PROJECT: **FR. HAYES STAIR RETROFIT PROJECT FOR**
ST. BRIGID CATHOLIC SCHOOL
695 STEVENS AVENUE
PORTLAND, MAINE 04103

Jonathan Rioux - 695 Stevens Ave.

From: Jonathan Rioux
To: davidleasure@myfairpoint.net
Date: 9/12/2012 9:25 AM
Subject: 695 Stevens Ave.
CC: Pirone, Chris; Wallace, Benjamin

FH-A-200 R1

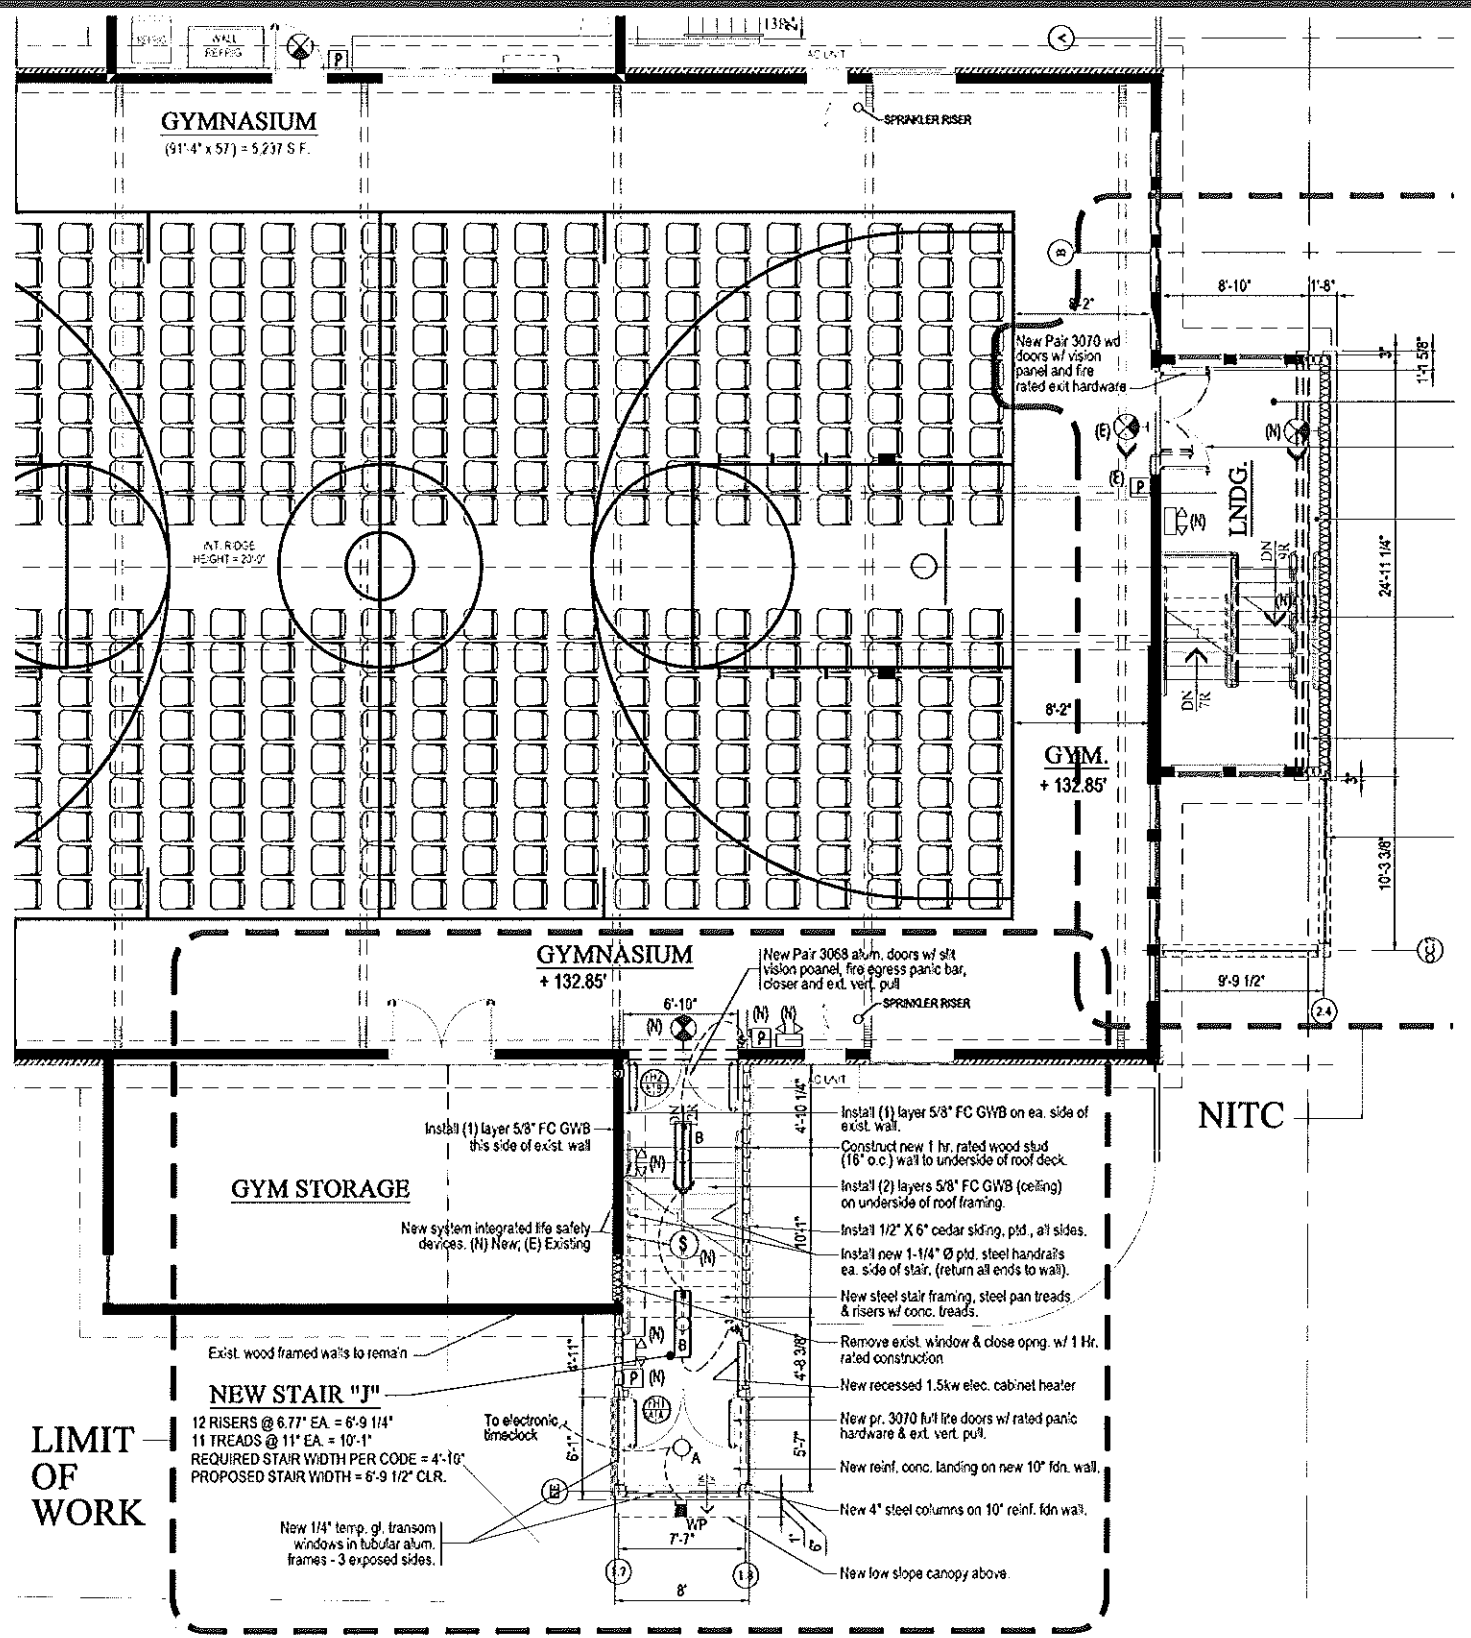
- The submission indicates the stair is to serve as a required means of egress but does not provide a life safety plan indicating occupant load of the space being served and how that's be accommodated. Need a complete seating plan and egress arrangement for the space. I don't believe the gym was approved for assembly use prior to this, and I think that change must be what has triggered the need for another exit and capacity.
- The headroom for the new stair does not comply with 101:43.8.1.1(1) and 101:7.1.5 for headroom at the top landing and door.
